**AS PLATTED**  
**REC. NO. 220714638**

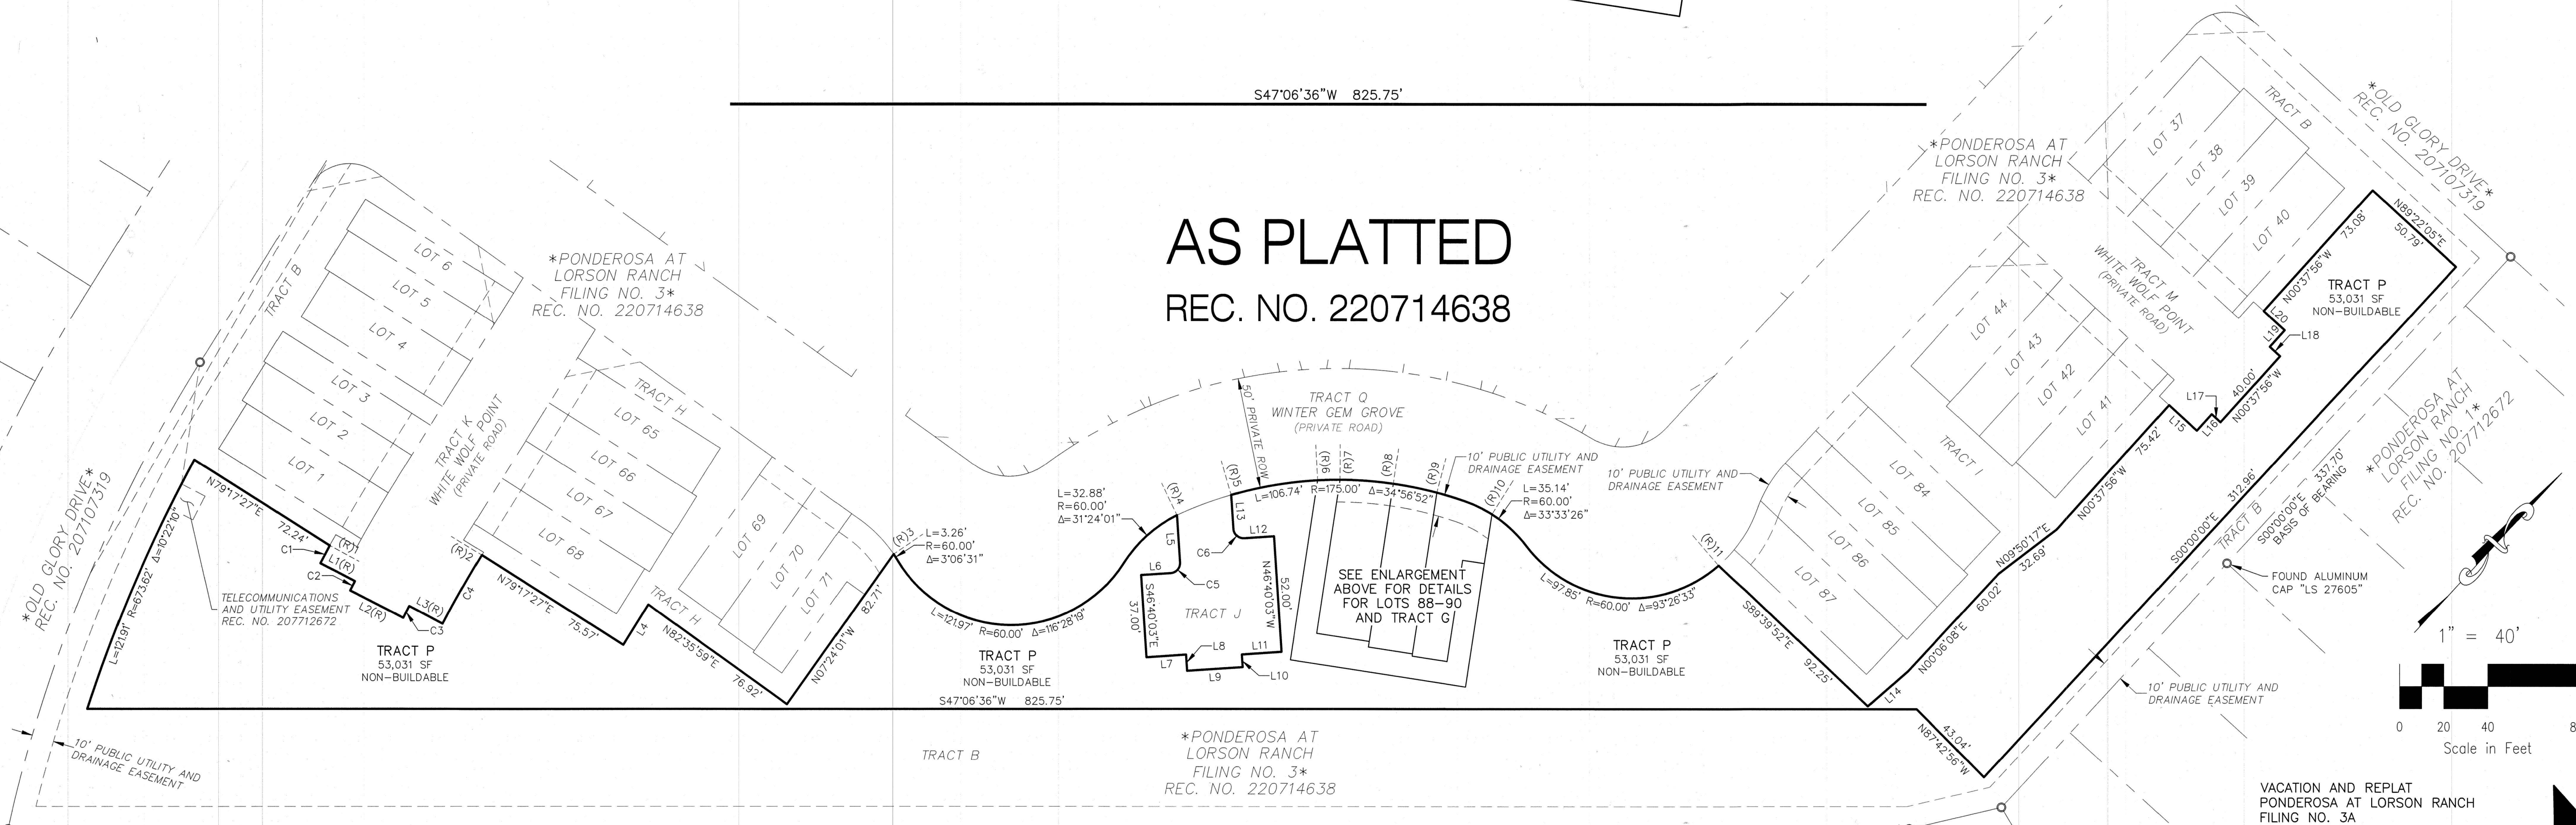
we need to see al of tract p along with its demensions.

Per previous set of redlines, please remove this and only show the two details below. Everything within the red cloud needs to be removed. The two details below should be the focus of this page and not just small details.

Overall display modified to only show all of Tract P (with only immediately adjoining lots and tracts included) together with an enlarged detail; now there are two sheets, one sheet created to show as platted parcels being vacated, and another to show parcels as they will be replatted.

**AS REPLATTED**

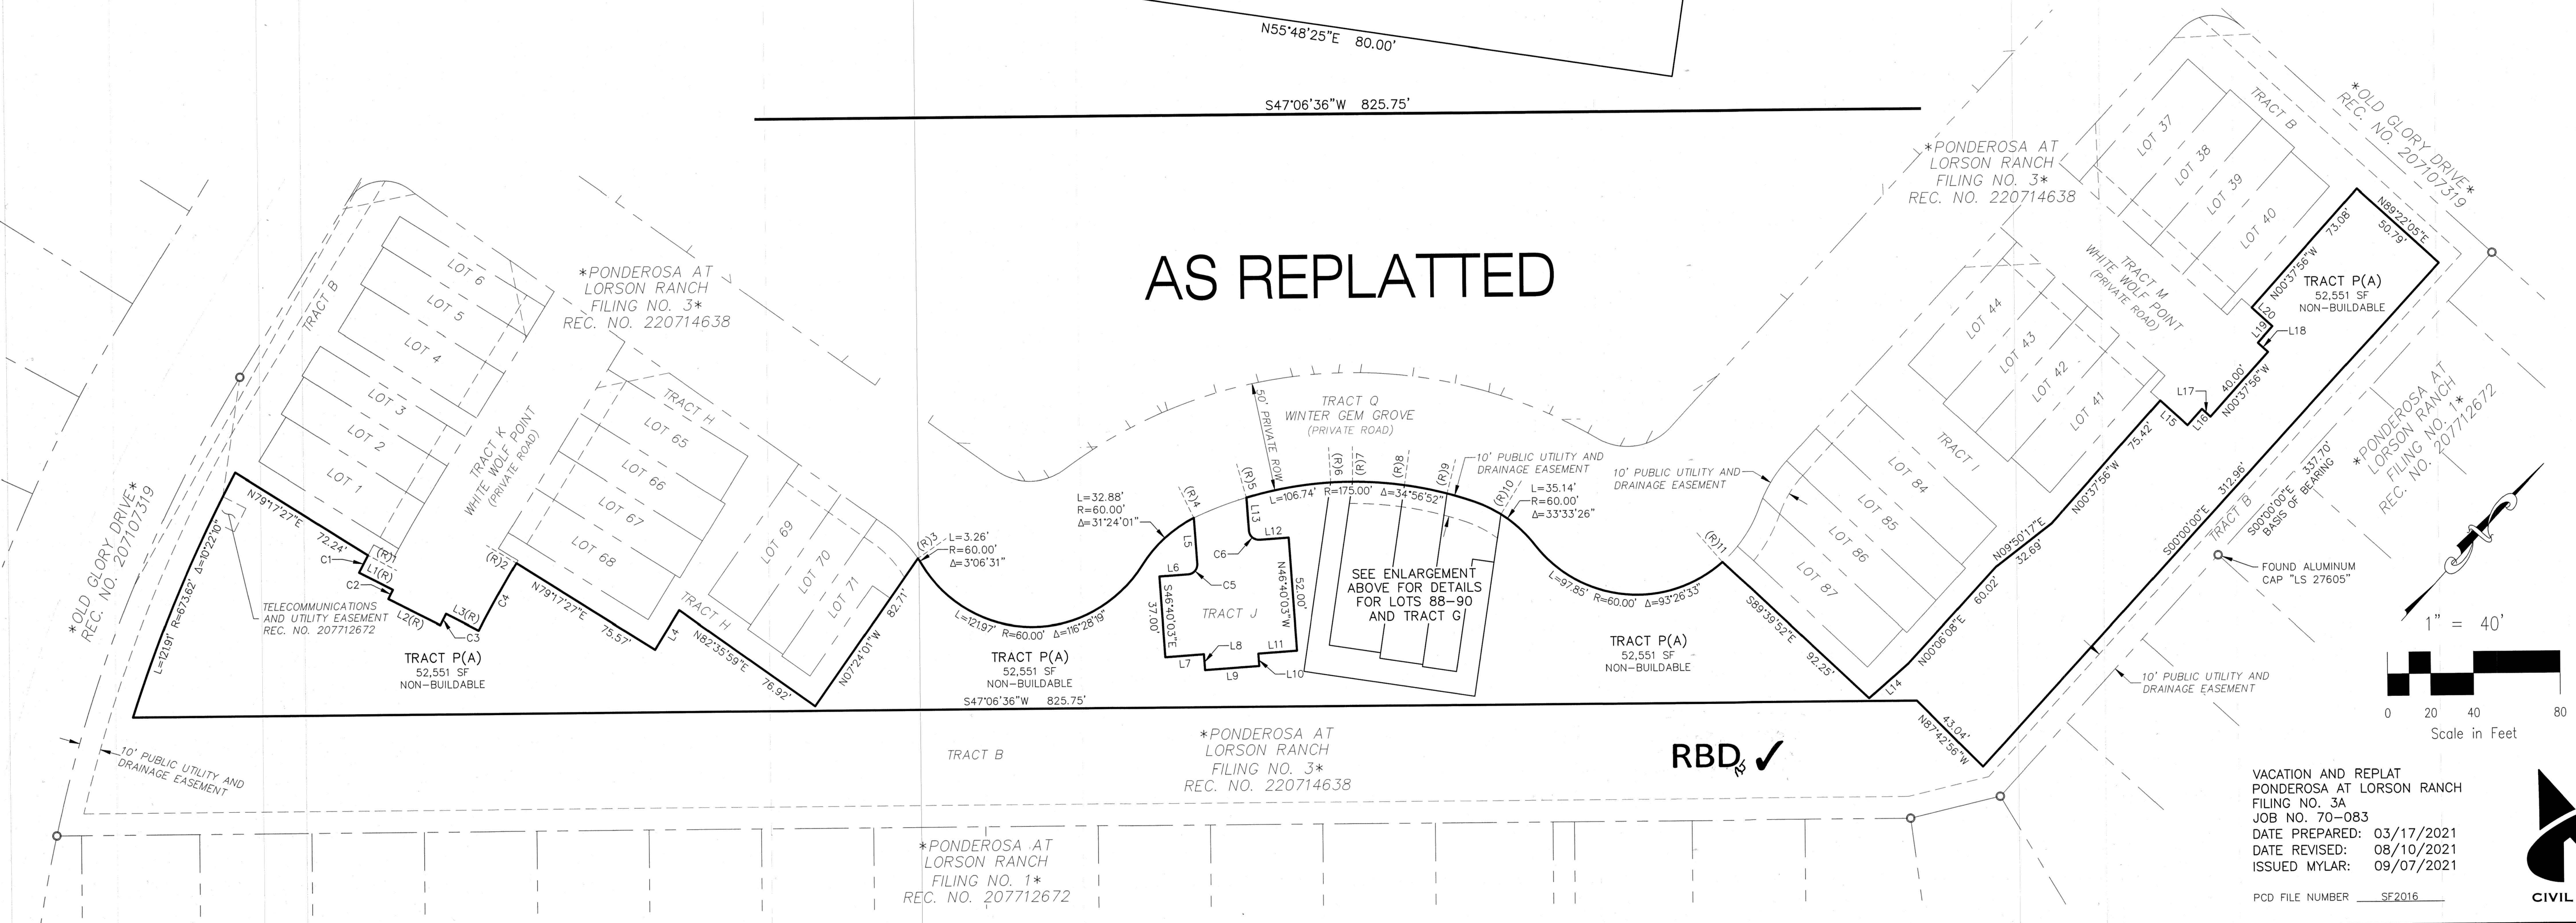
per previous set of redlines, tracts g and p need to have one of the following labels added to their label:

- "Buildable/Support Buildings Only" for those common area tracts that may be occupied by buildings or structures that are intended for use by the lot owners within the subdivision;
- "Non-Buildable" for those common area tracts that are not intended to be occupied by buildings or structures.

Buildable/non-buildable labels added.

SHEET 1 OF 2

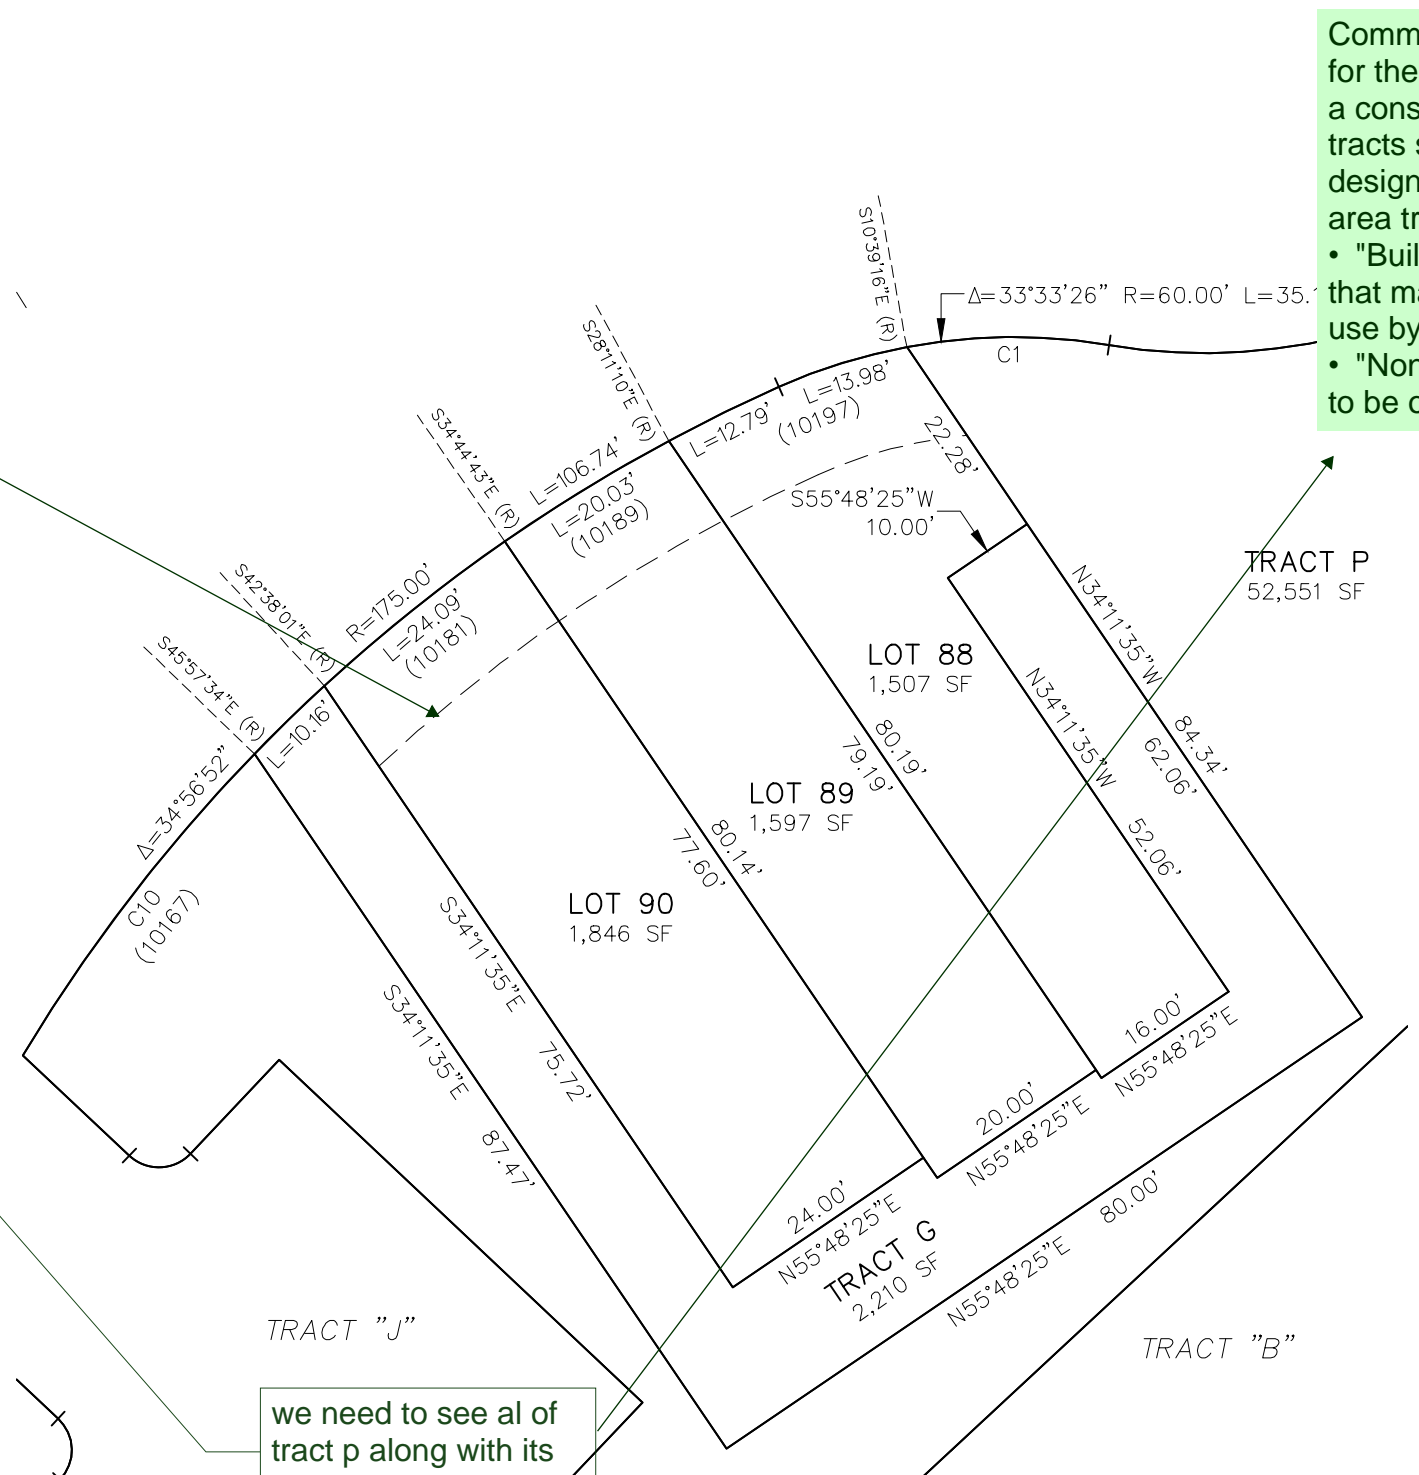
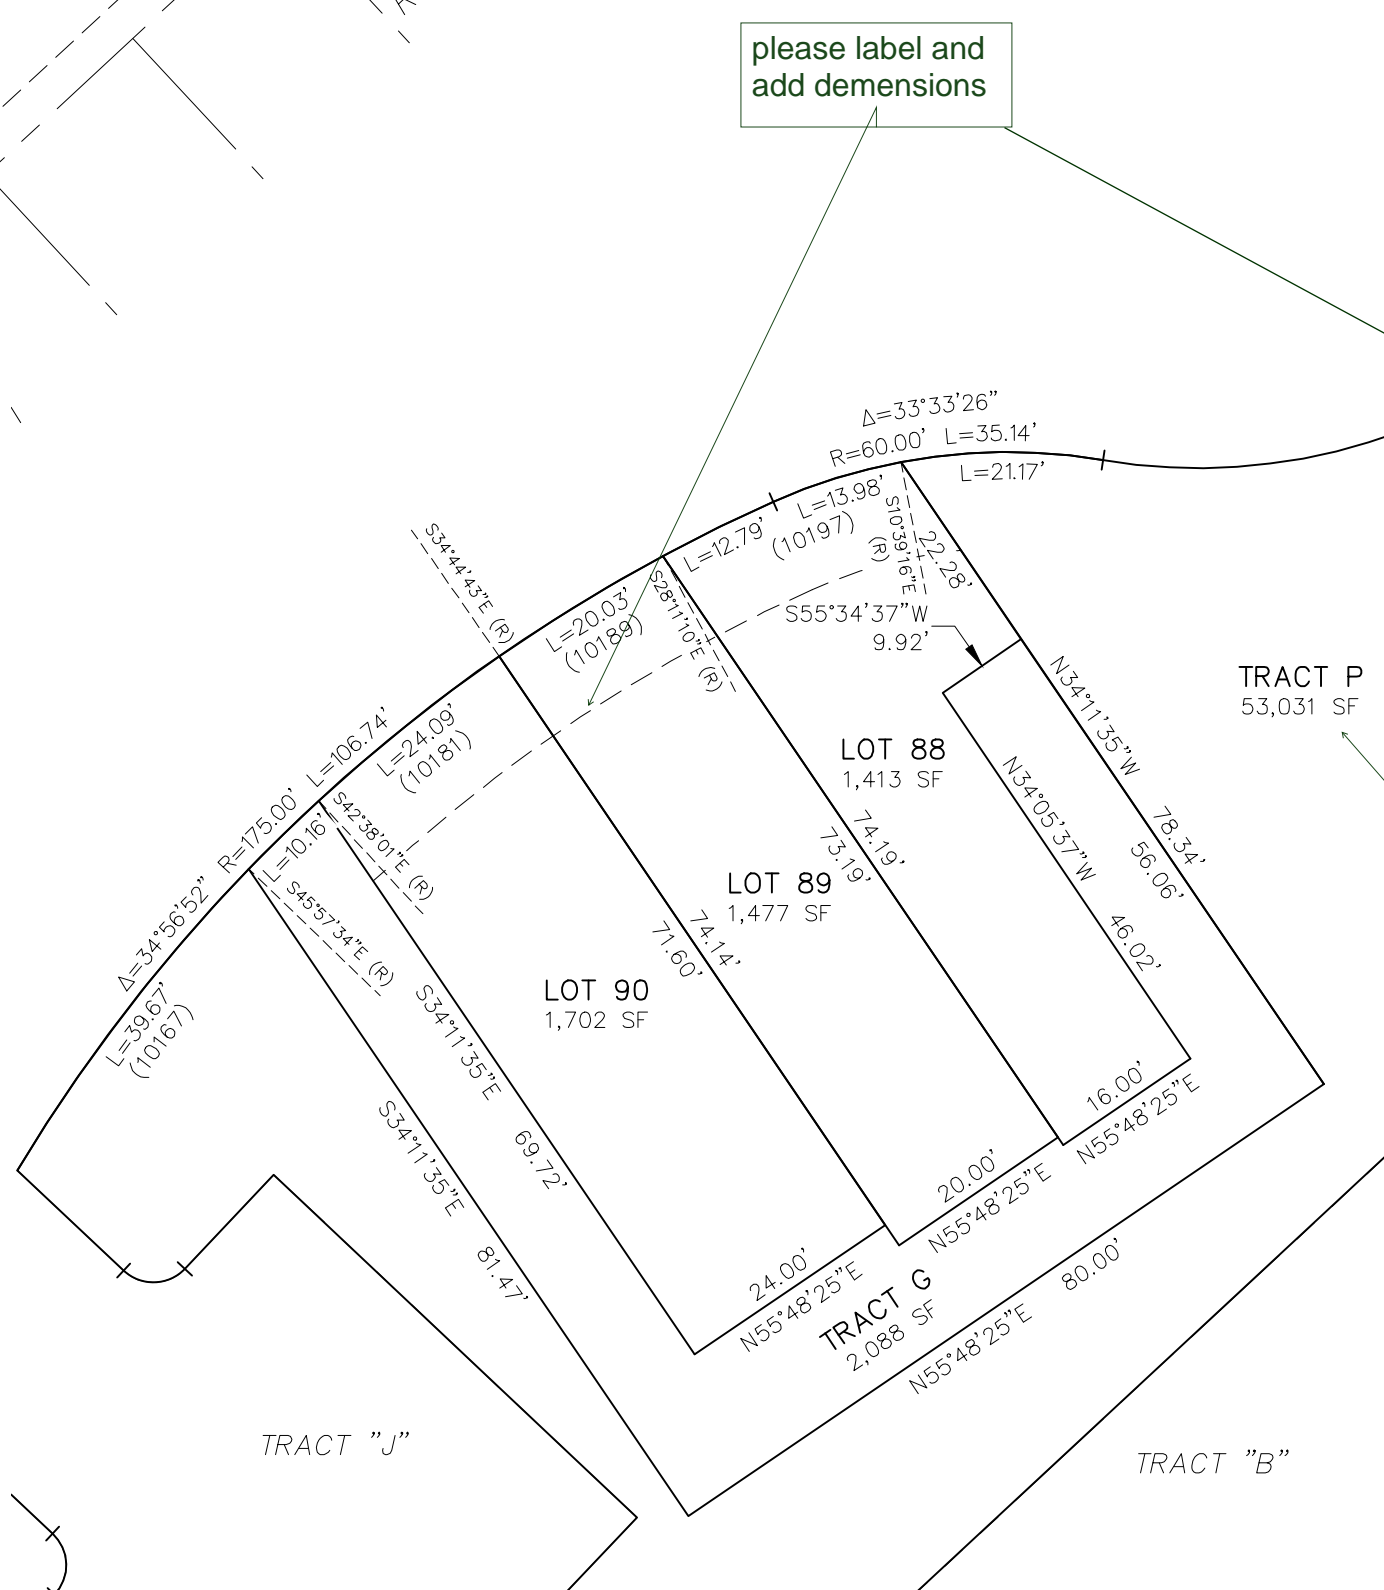
-The PUD amendment would need to be approved prior to replat being approved.

enlarge both of these details to fill the page.

reference detail

PUD amendment recorded May 20, 2021 under reception no. 221099720.

Detail removed. The enlarged detail areas are now large enough to label the easement without needing a separate easement detail.

Overall display modified to only show all of Tract P (with only immediately adjoining lots and tracts included) together with an enlarged detail; now there are two sheets, one sheet created to show as platted parcels being vacated, and another to show parcels as they will be replatted.

Overall display modified to only show all of Tract P (with only immediately adjoining lots and tracts included) together with an enlarged detail; now there are two sheets, one sheet created to show as platted parcels being vacated, and another to show parcels as they will be replatted.
